**Chapter V - Section 55
Subdivision Summary Form**

County: **EL PASO COUNTY**

GRANDVIEW RESERVE PHASE 3 PUD DEVELOPMENT PLAN & PRELIMINARY PLAN

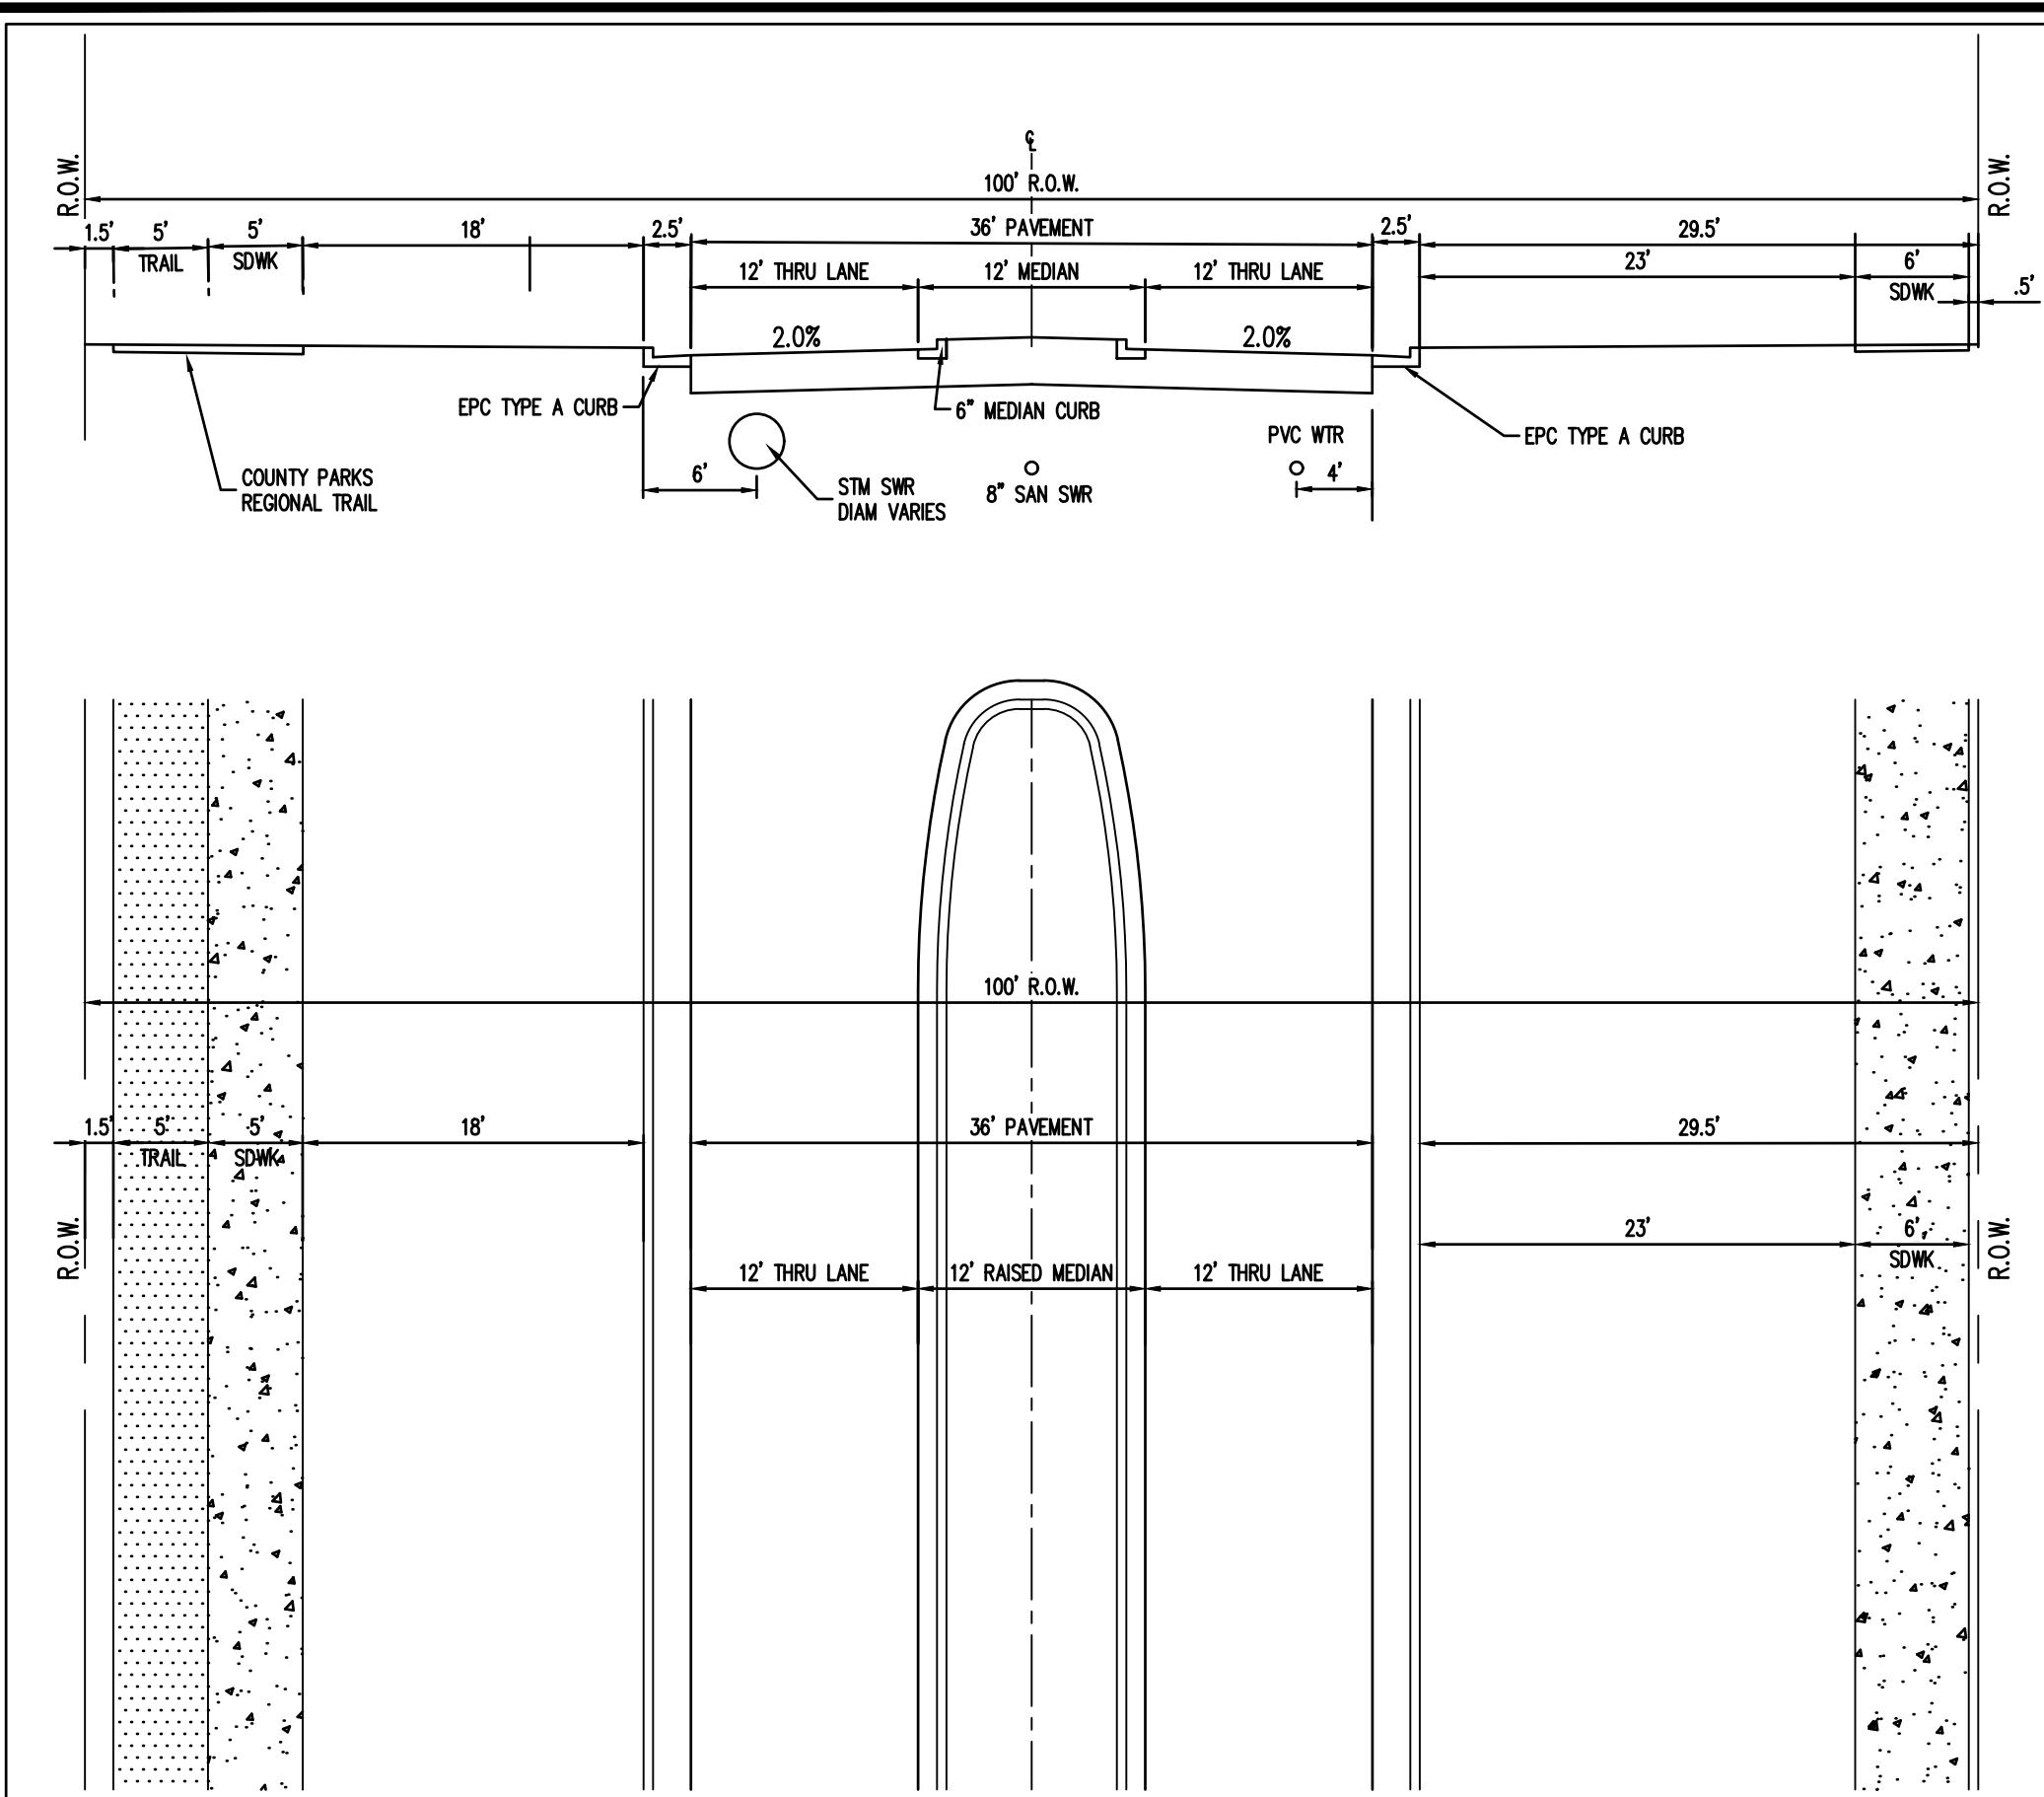
Area doesn't match with area shown on preliminary plan cover sheet
